CDP  
House 6  
Tukes Avenue  
Bridgemary  
Gosport  
PO13 0SE

Please ask for: Ms Iqraa Malik  
Email: [iqraa.malik@terraquest.co.uk](mailto:iqraa.malik@terraquest.co.uk)  
Telephone: 01212341390  
Our Ref: AL/73/21/HH  
Your Ref:  
Date: 14th June 2021

**Application for Planning Permission for Works or Extension to a Dwelling**

**Development:** Erection of part single storey side/rear extension and part two storey side extension with 3 x front dormers following the demolition of existing  
**Location:** 26 Meadow Way Westergate Aldingbourne PO20 3QT

26 Meadow way, Westergate, West sussex, PO20 3QT
Proposed new extension
Site Location and Block Plan

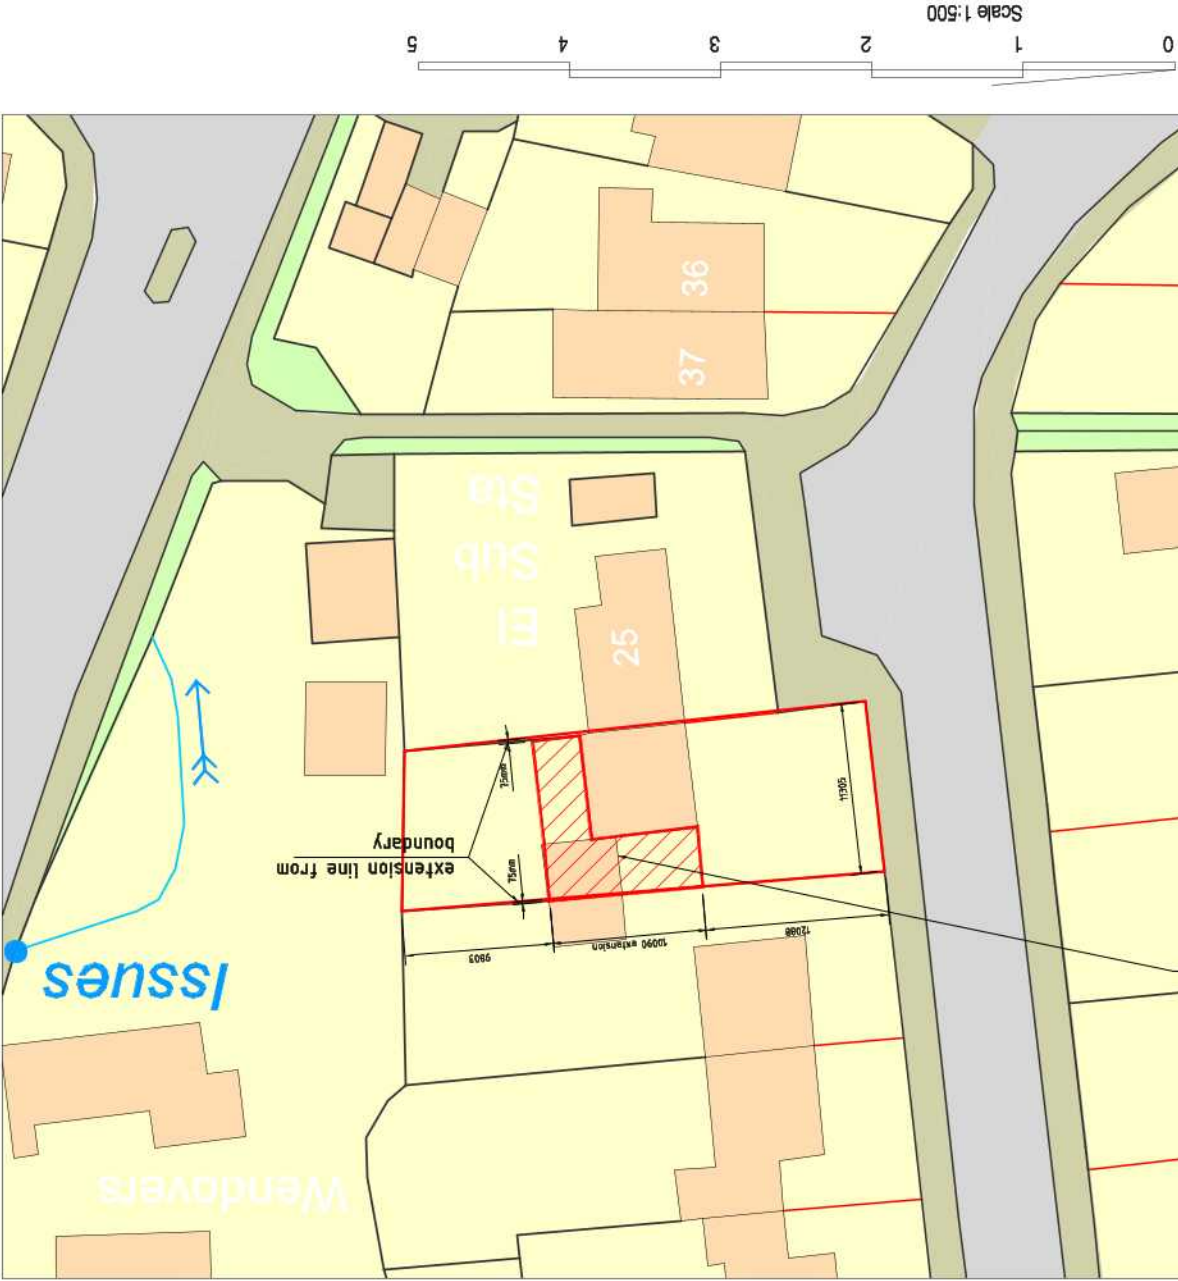
You are required to have dimensions from the proposed extension(s) to all site boundaries. Please amend
